Your reference: SSD-8911
Our reference: DOC23/593564

Environmental Impact Assessment - State Significant Development – Sundown Solar Farm – SSD-8911

Attachment A – Detailed Aboriginal Cultural Heritage Advice

Sundown Solar Farm
Submissions Report
Figure 4.4

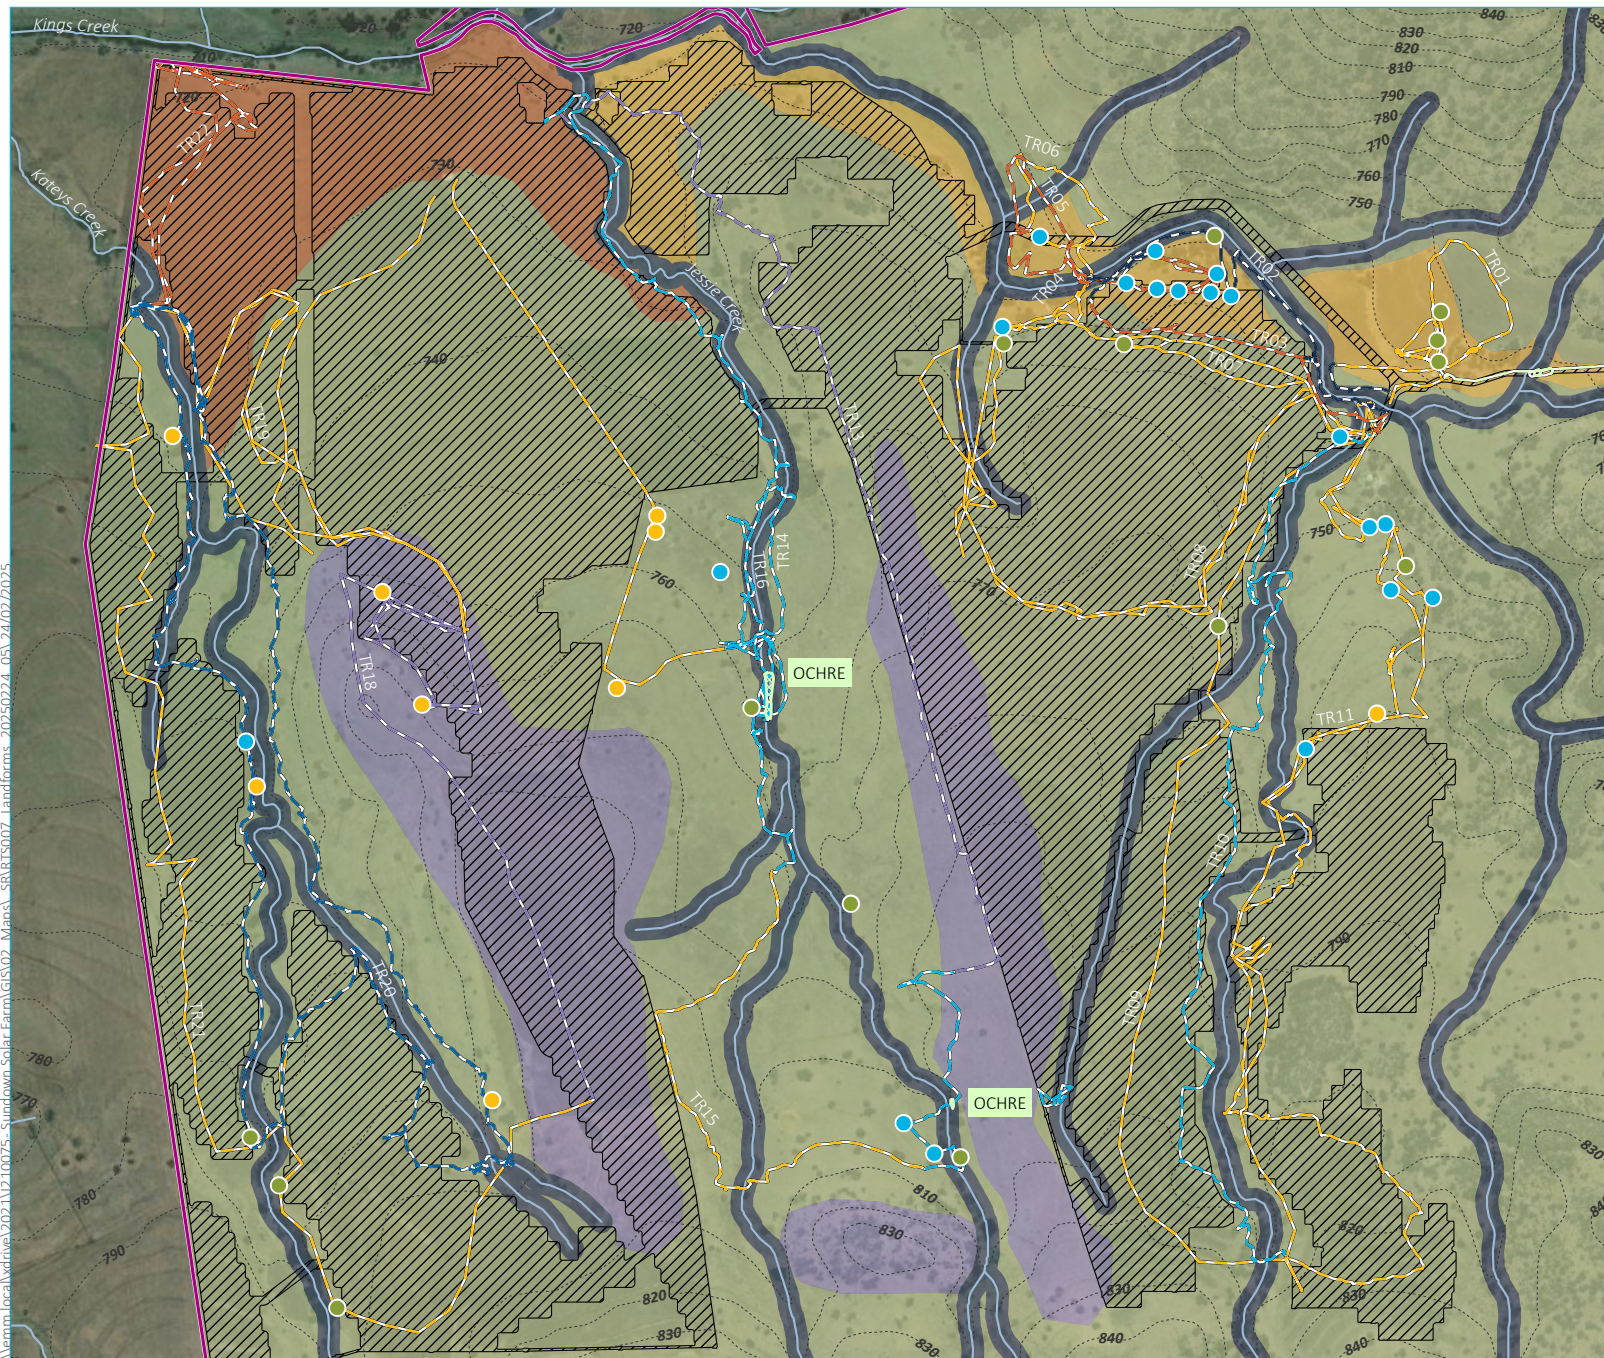
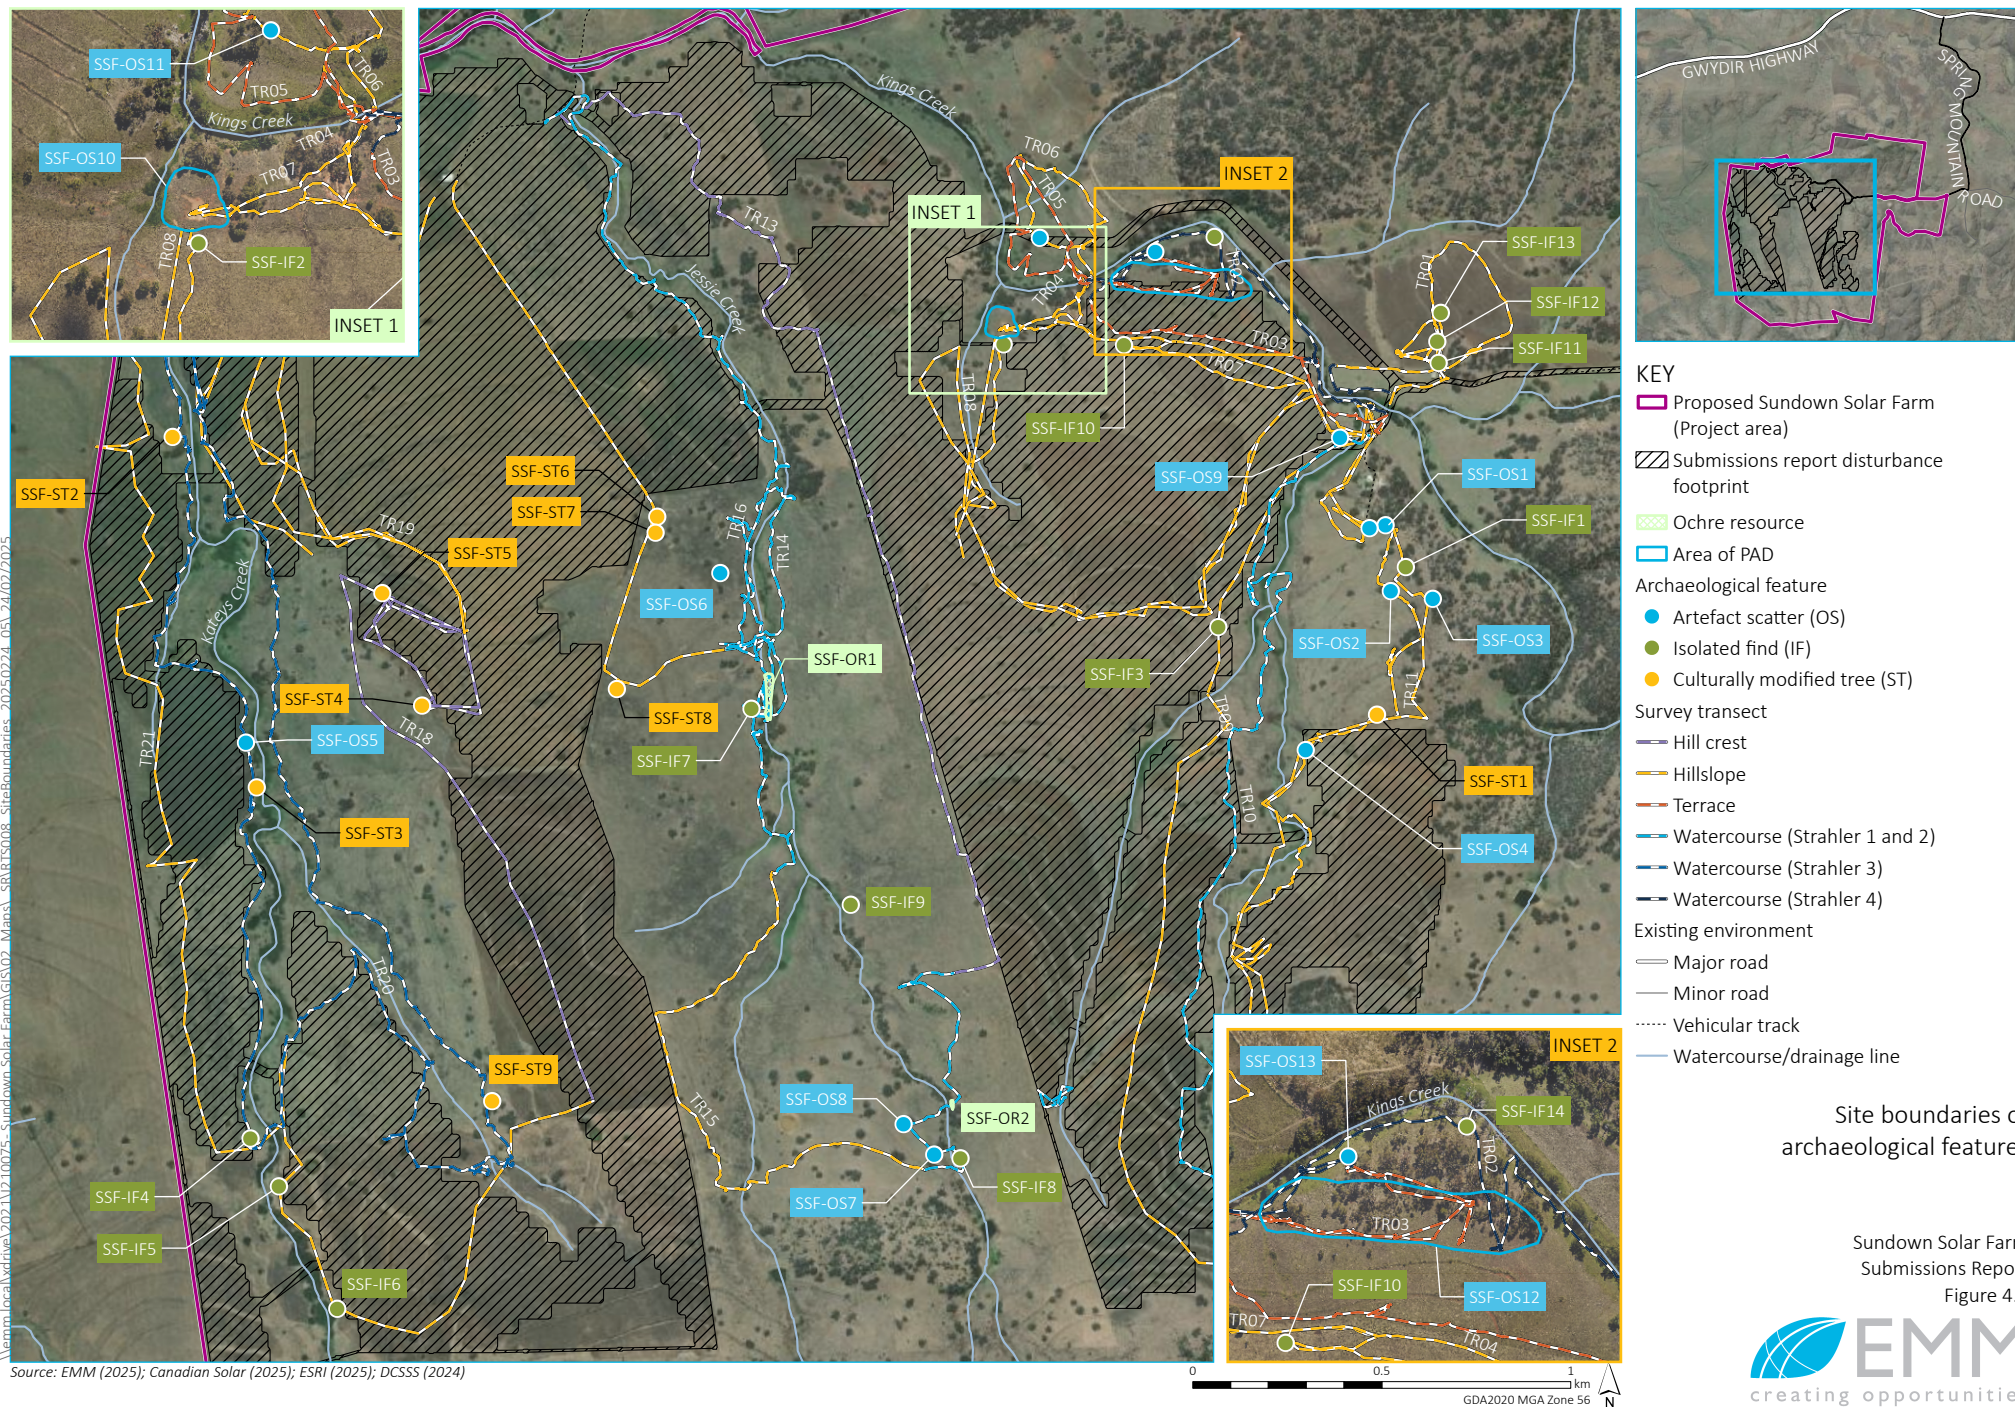
- Heritage NSW notes that the Aboriginal Heritage Information Management System (AHIMS) search is greater than 12 months old at the time of submission. Heritage NSW generally requires, as per Requirement 1b of the *Code of Practice*, that AHIMS searches are less than 12 months old. Please provide an updated AHIMS search.
- Please update the ACHAR to include all relevant AHIMS site numbers.
- Please provide additional mapping to clarify the survey transects and their relationship with the project boundary, project infrastructure, PV arrays, and landforms.
- Please update mapping to include site boundaries of artefact scatters.
